WEST SUSSEX COUNTY COUNCIL CONSULTATION

TO:	Arun District Council FAO: Anita Gardner
FROM:	WSCC - Highways Authority
DATE:	5 August 2021
LOCATION:	3-4 Selborne Place Selborne Road Littlehampton BN17 5NH
SUBJECT:	LU/212/21/PL Change of use from A3 Restaurant / A4 Drinking Establishment to C3 Dwelling Houses (5 No. 1-bed flats & 1 No. 2-bed flat). This application may affect the setting of a listed building, may affect the character & appearance of the Littlehampton Sea Front Conservation Area & is in CIL Zone 4 (Zero Rated) as flats.
DATE OF SITE VISIT:	n/a
RECOMMENDATION:	No Objection
S106 CONTRIBUTION TOTAL:	n/a

Block Plan
Scale 1:500

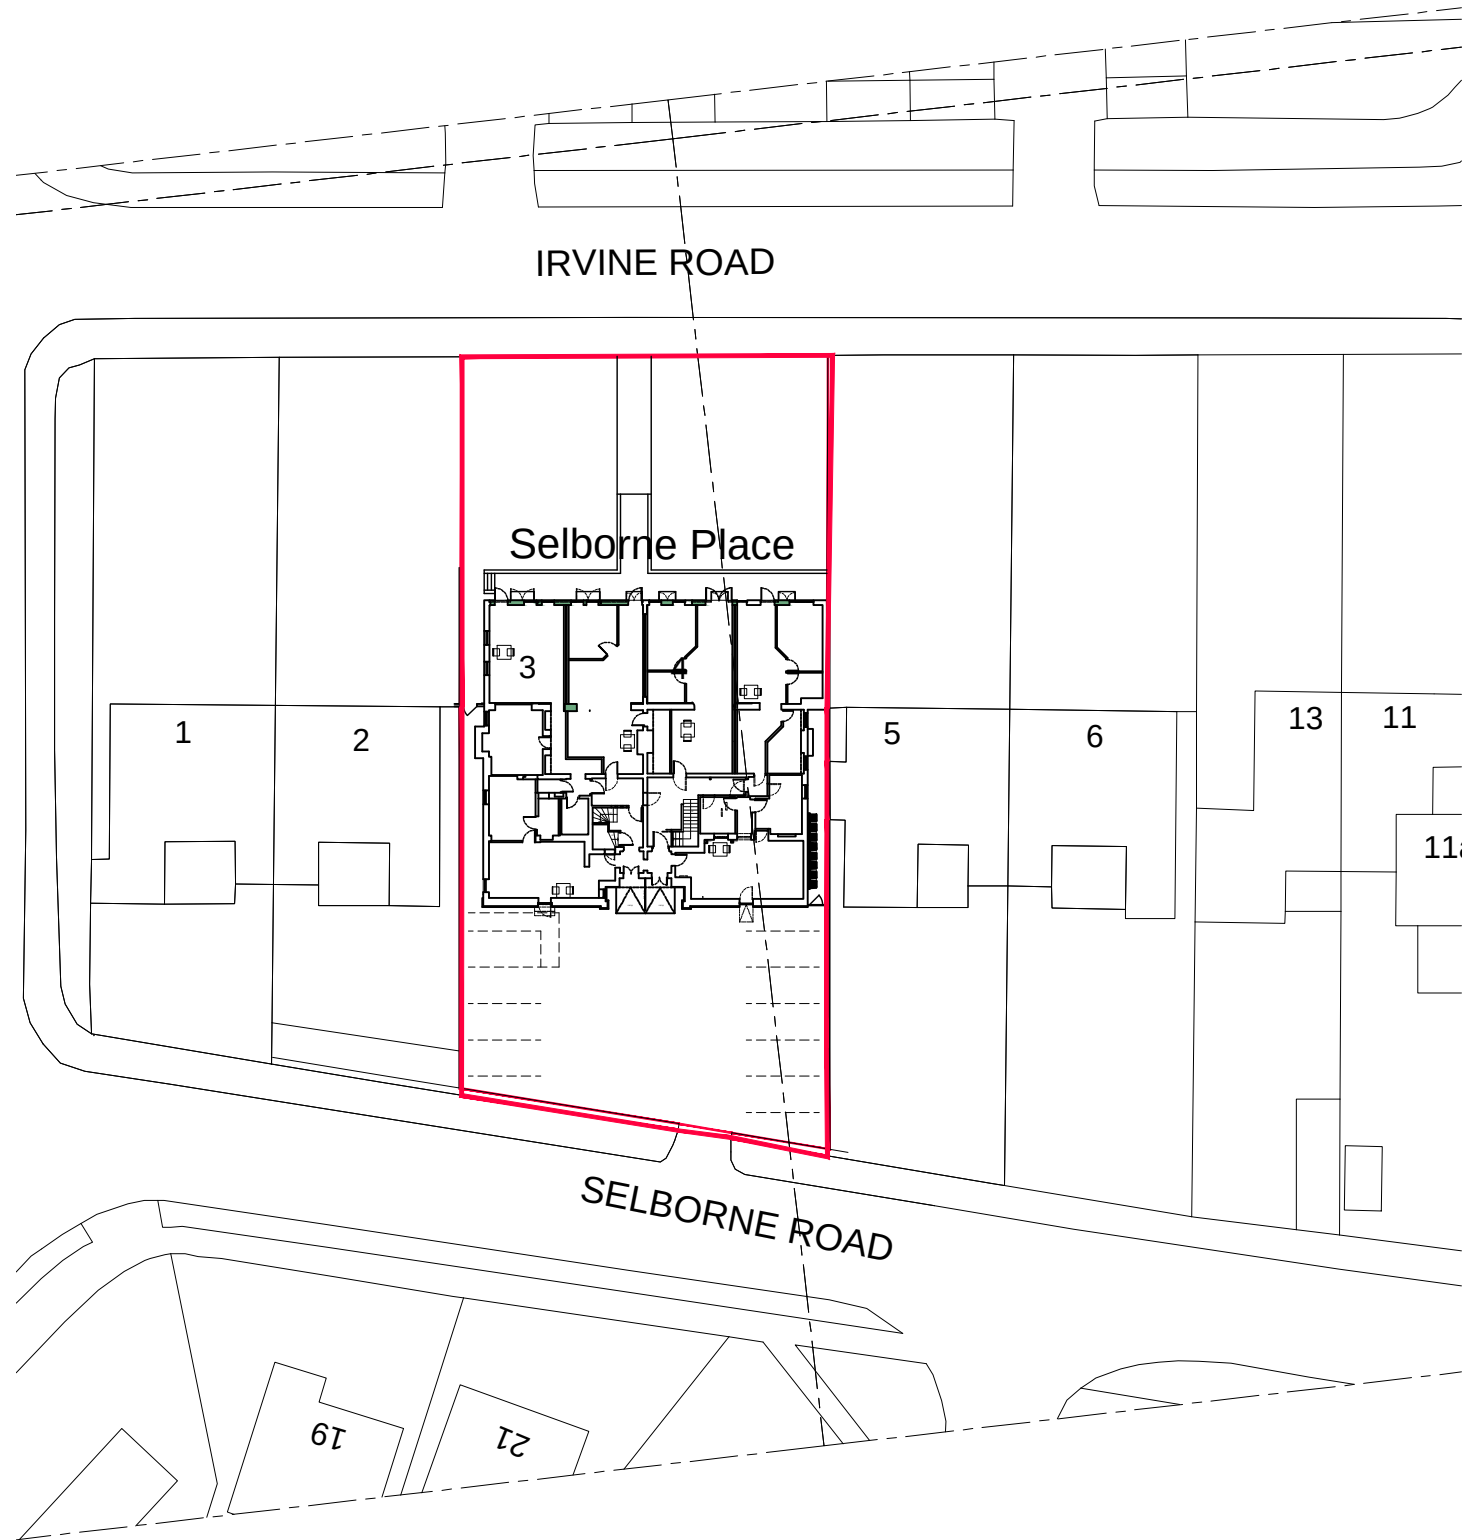
The site is currently being used as a Restaurant with 10 car parking spaces located to the front of the site. The proposal is for the conversion of the building to residential dwellings. No changes are proposed to the parking area or the vehicular access onto Selborne Road.

The Highway Authority would not wish to raise an objection to the proposal, however secure and covered cycle storage and suitable bin storage

No objection subject to the following conditions.

No part of the development shall be first occupied until covered and secure cycle parking spaces (2 per dwelling) have been provided in accordance with plans and details submitted to and approved by the Local Planning Authority.
